From: Geoffrey Gray <gg@gg-env.com>
Sent: Monday, September 22, 2025 11:00 AM
To: Ellie Myers; Ian Garrity
Cc: Josh Pozzobon; Jamey Ayling
Subject: RE: CARA Referral

SITE PLAN - NEIGHBORING PROPERTIES

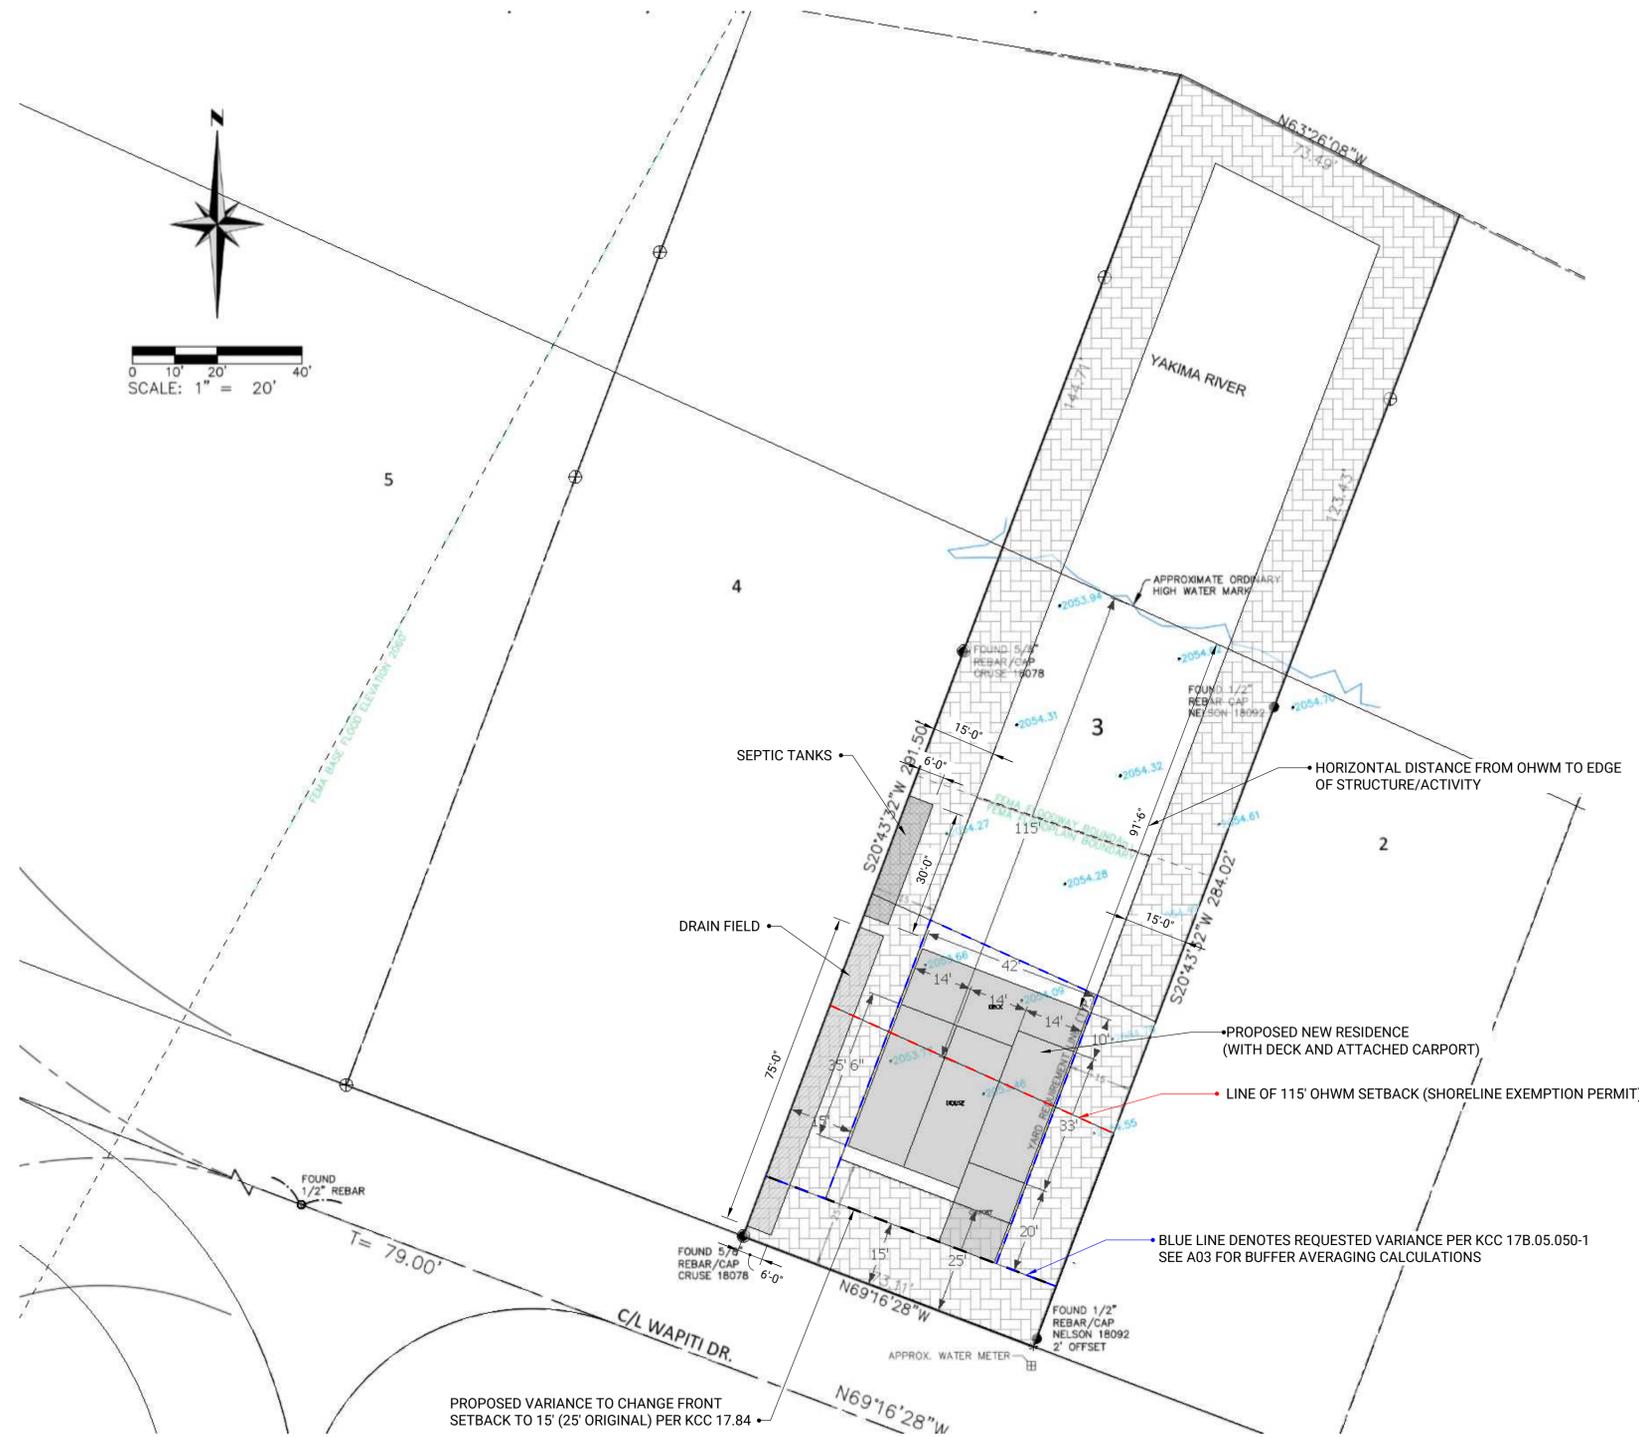
When we refer to "establishing a 115-foot buffer and setback on the eastern property," we are not designating the entire eastern property line of 1151 Wapiti Dr as a non-buildable shoreline buffer.

Instead, we are using the 115-foot measurement from the ordinary high water mark (OHWM) of the *eastern property* to establish a theoretical boundary for the purposes of applying the *common line setback* approach. This line helps define the setback for the proposed development on the subject property.

The Common Line Shoreline Buffer, outlined in KCC 17B.06.200(B)(7), allows an applicant to place a residence on a vacant lot if single-family homes exist on both adjacent lots, which we previously stated couldn't be used because the eastern lot is vacant. However, we are comfortable proceeding with the idea of establishing a 115-foot buffer and setback on the eastern property line. This would represent the maximum distance at which a house could be placed on this lot.

To move forward, you will need to determine the exact distance from the Ordinary High Water Mark (OHWM) to the cabin located at 1181 Wapiti Dr. Although satellite imagery suggests the cabin is approximately 65 feet from the river, a more accurate, on-the-ground measurement will be required. Please do not access private property without permission.

Once you have that measurement, you will calculate the average of that distance and 100 feet. Then, you'll need to add the standard 15-foot building setback and apply the 25% reduction allowed under KCC 17B.06.200(B)(12), which results in a final setback of 11.25 feet.

This approach would not require any enhancement of the shoreline buffer elsewhere on the property and would not trigger the need for a Critical Aquifer Recharge Area (CARA) review. However, a mitigation plan will still be required and must be prepared by a qualified professional. Anyone from the list I previously provided should be able to assist with this.
